# Submissions Report

Florida Street, Sylvania, State Significant Development

SSD-83258708

29 Florida Street, Sylvania

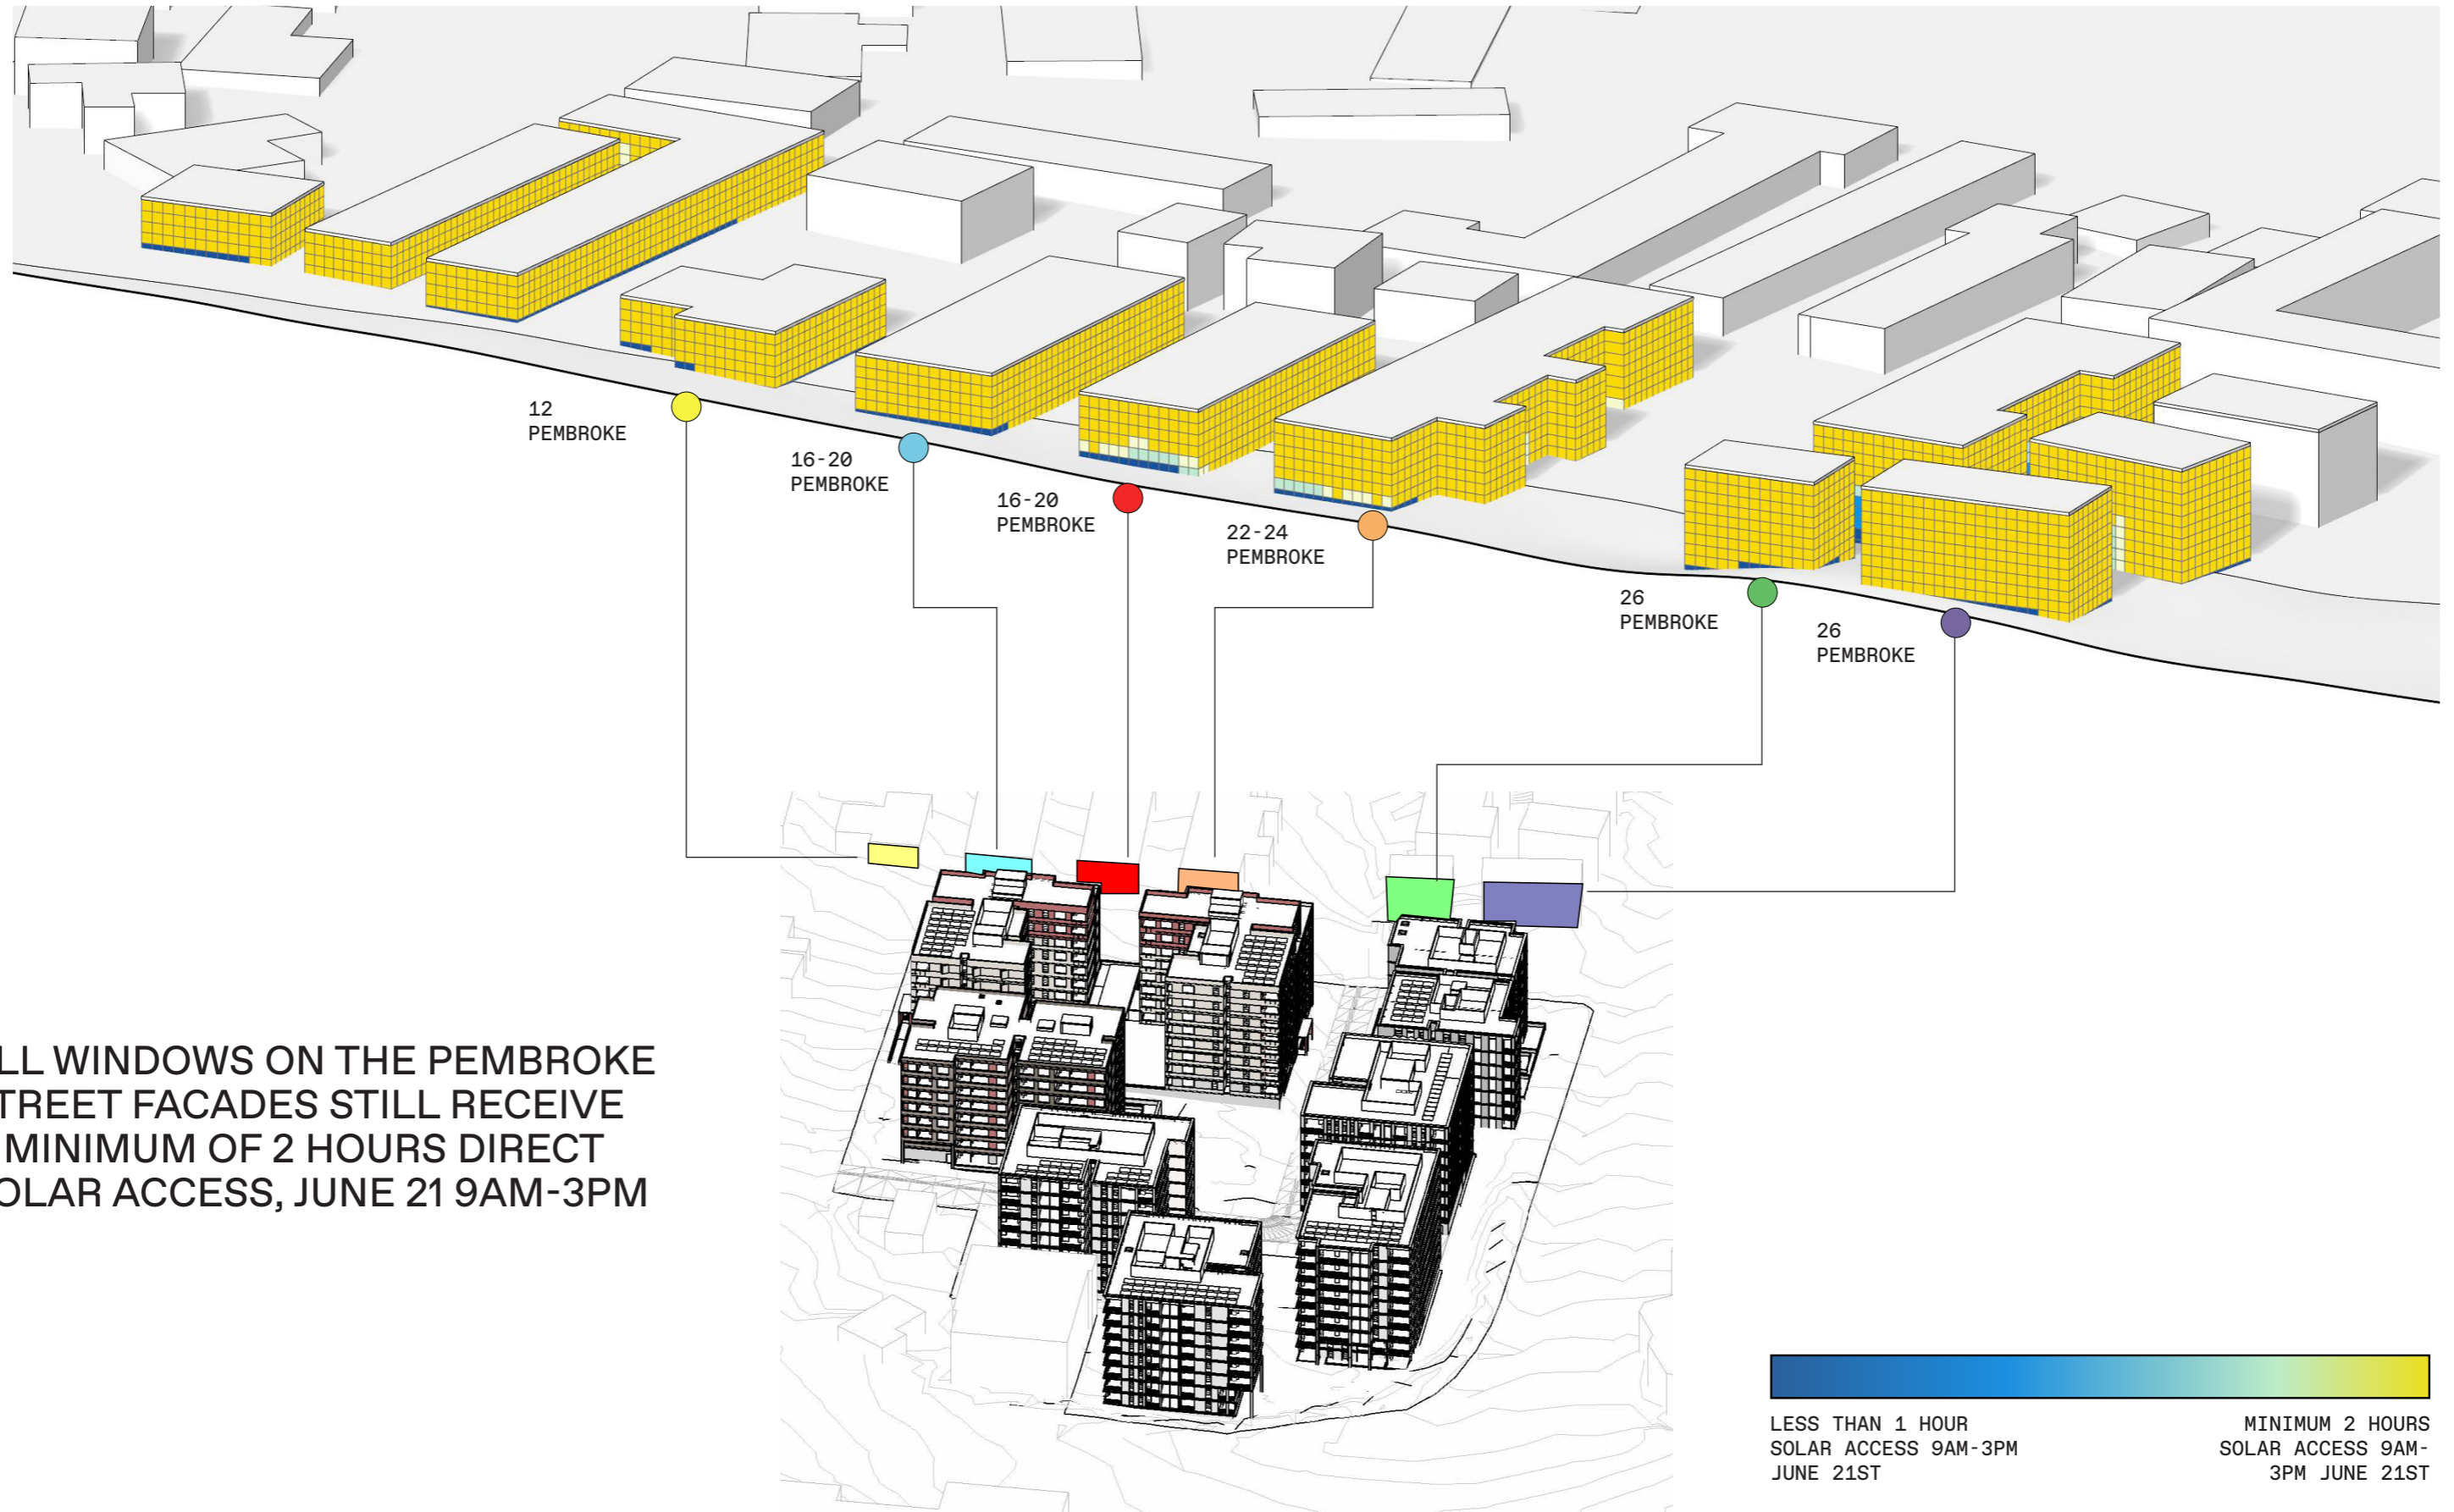
<b>2. Built form and urban design</b>		
2.1	To minimise the bulk and scale of the proposal, overshadowing impacts to 16 to	As outlined in the Design Response prepared by BVN at Appendix B, the proposed built form and

No.	Issue raised	Response
	<p>26 Pembroke Street and to improve the transition to the adjoining R3 Medium Density Residential and R2 Low Density Residential zoned areas, consideration should be given to redistributing building mass to the north of the site and increase building heights fronting Princes Highway and Port Hacking Road to allow for lower building heights along Pembroke Street and Florida Street.</p>	<p>distribution of height have been carefully considered. It should also be noted at 2.05:1 the proposal is substantially below the maximum permitted FSR of 2.86:1.</p> <p>The proposed buildings have been carefully planned and designed to maximise the retention of high value trees, enhance open space and landscaping to create a series of buildings centred around a network of generous new communal open spaces.</p> <p>The proposal has been subject to a design review process, and in response to State Design Review Panel (SDRP) feedback, the design was refined to reduce perceived scale and massing of the social housing building while maximising the delivery of social housing in the first stage of development. These refinements focused on breaking down the building form and redistributing height to moderate bulk when viewed from the public domain.</p> <p>As confirmed by BVN, the proposed distribution of built form does result in any adverse amenity impacts to neighbouring properties or internal communal spaces, and compliance with the solar access provisions of the ADG is achieved.</p> <p>The proposal provides a considered transition to adjoining R3 and R2 zoned land through:</p> <ul style="list-style-type: none"> <li>• reduced street wall height and articulated upper levels along Pembroke Street to reduce visual impacts.</li> <li>• modulation of built form to reduce perceived bulk and scale.</li> <li>• substantial landscaped setbacks that provide an appropriate interface to neighbouring residential development – including a minimum 10m front setback and retention of existing trees along Pembroke Street and Florida Street.</li> </ul> <p>Further, the site is in an area of planned increased density, with surrounding areas envisaged to transition to higher density residential buildings of up to 6-storeys in the short to medium term in accordance with the low and mid rise (LMR) housing provisions. The proposal responds to the existing and future context, ensuring a high level of amenity for neighbouring properties, while recognising surrounding sites may redevelop in the future for higher density residential development.</p> <p>As demonstrated in the solar analysis provided by BVN at Appendix B:</p> <ul style="list-style-type: none"> <li>• overshadowing impacts properties on Pembroke Street are minor and primarily confined to lower façade levels;</li> </ul>

No.	Issue raised	Response
		<ul style="list-style-type: none"> <li>• all neighbouring properties will continue to receive more than 2hrs solar access in mid-winter, and</li> <li>• the extent of shadow cast is broadly comparable to a height-compliant massing.</li> </ul> <p>Accordingly, the proposal does not result in unreasonable amenity impacts which justify a redistribution of building mass and height across the site.</p> <p>The distribution of built form across the site has also been carefully considered in response to staging constraints and the physical characteristics of the site. The staged delivery of the project limits the location and configuration of the social housing building which is required to be delivered within the south-eastern portion of the site.</p> <p>The proposed massing and distribution of built form across the site is intrinsically linked to the delivery and management of the social housing building.</p> <p>The proposed building distribution been developed in coordination with Homes NSW to ensure the project can:</p> <ul style="list-style-type: none"> <li>• efficiently deliver social housing dwellings</li> <li>• support appropriate building management, operational oversight, and resident accessibility outcomes; and</li> <li>• integrate social housing within the broader development in a manner consistent with contemporary tenure-blind design principles.</li> </ul> <p>Redistribution of building mass as suggested would materially affect the functional planning, staging and delivery social housing, reducing operational efficiency and limiting Homes NSW's ability to manage both existing and future social housing outcomes. The proposal is also significantly below the maximum density permitted on the site.</p> <p>Further, relocating additional building height toward Princes Highway and Port Hacking Road would not result in improved environmental outcomes as it would:</p> <ul style="list-style-type: none"> <li>• concentrate bulk along primary frontages already accommodating higher traffic, noise and visual exposure.</li> <li>• reduce solar access to internal communal areas and apartments.</li> <li>• Require increased building separation to accommodate increased height – impacting the built form, communal open space and landscaping strategy.</li> </ul> <p>potentially introduce new amenity impacts without delivering any significant improvement to adjoining properties. On this basis, redistribution of building</p>

No.	Issue raised	Response
		height or built form is not considered necessary to achieve improved outcomes.
2.2	<p>The design of ground floor lobbies is to be reviewed to improve amenity, including:</p> <ul style="list-style-type: none"> <li>a) minimising the number of dead ends and increasing passive surveillance opportunities</li> <li>b) minimising reliance on artificial lighting and maximising access for natural light</li> <li>c) ensuring accessible access is provided to all lobbies.</li> </ul>	<p>The ground floor lobbies have been reviewed by BVN, and minor refinements are provided in the revised Architectural Plans at Appendix C.</p> <p>Refer Design Response prepared by BVN at Appendix B.</p>
<b>3. Stormwater and flooding</b>

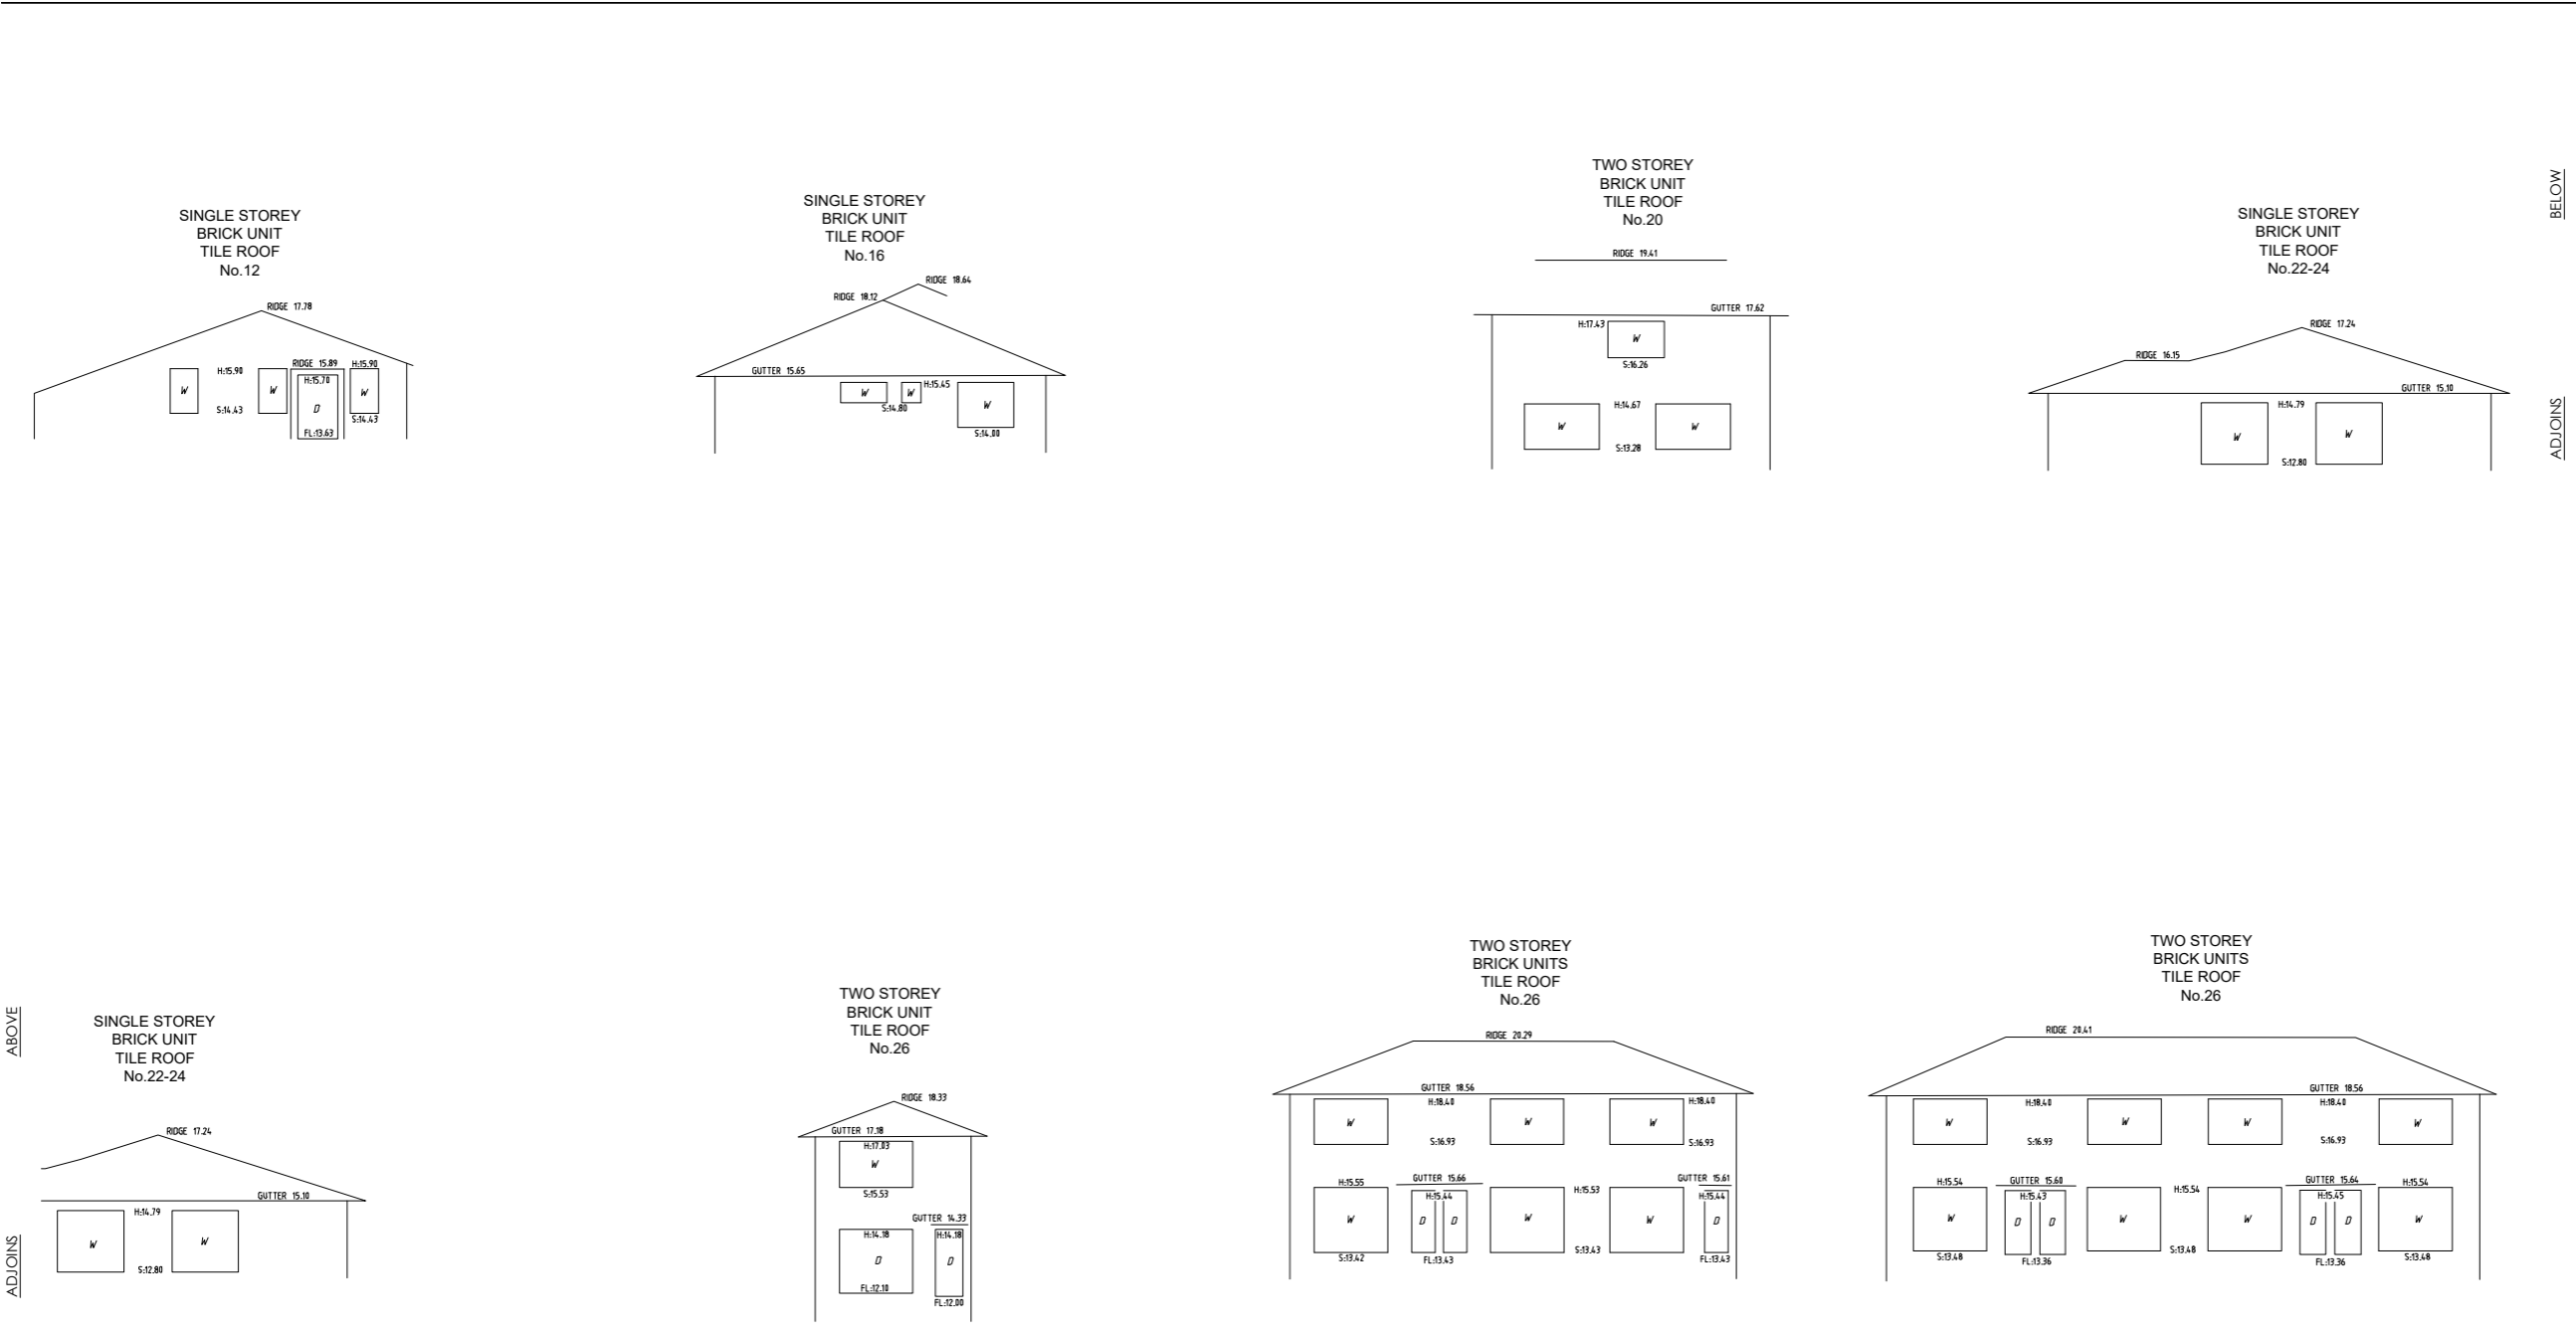
4.2	Provide modelling of the adjoining Pembroke Road residential buildings impacted by overshadowing, identifying areas of private open space and windows to habitable rooms, and quantify the duration and extent of overshadowing resulting from the proposal.	This is addressed in the Design Response prepared by BVN at Appendix B and the response above (Item 4.1).
<b>5. Privacy and amenity</b>
